Our reference: ECM: 9347244  
Contact: Kate Smith  
Telephone: 02 4732 7705

5 November 2020

**Response to Request of SEARs for SSD-10272349 - GPT Industrial Estate at 784-786 Mamre Road Kemps Creek**

FUNCTIONAL LAYOUT PLAN
SCALE 1:250

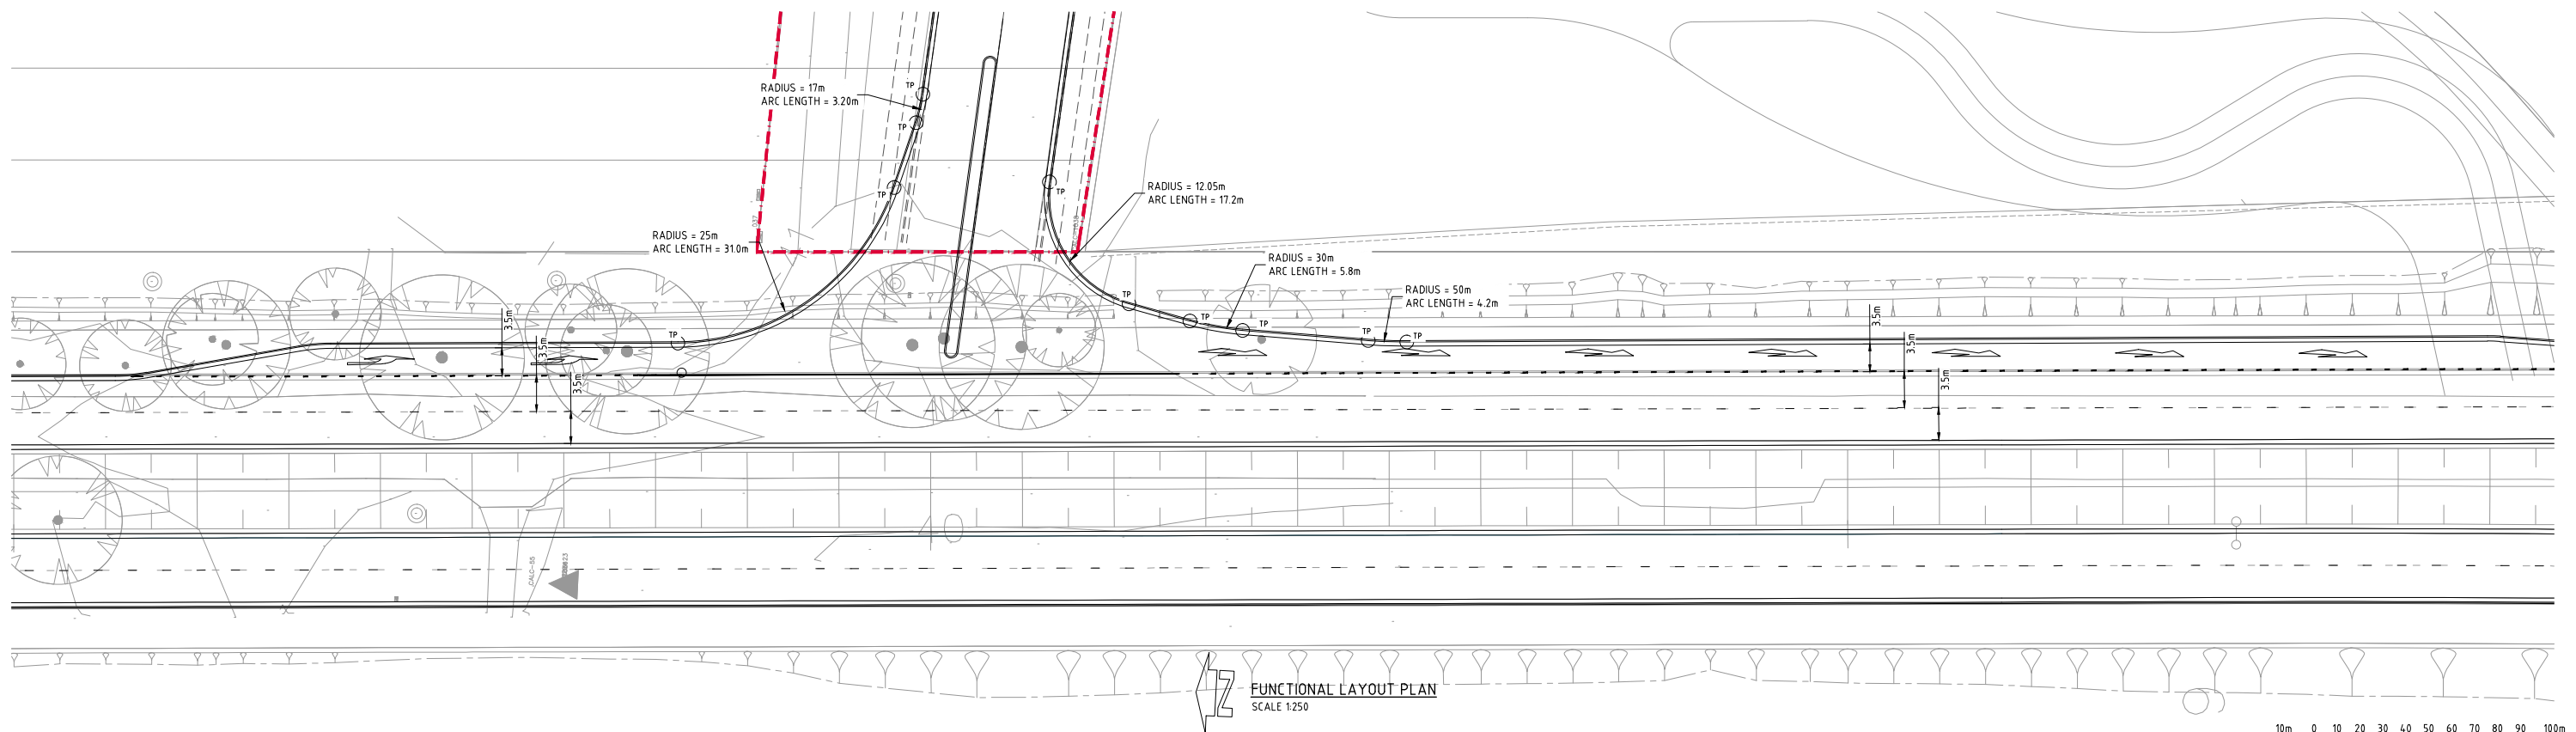
- Council do not support any direct driveway access to Mamre Road. As such, Council does not support the proposed driveway from warehouse 5 to Mamre Road or the proposed temporary access road to Mamre Road.
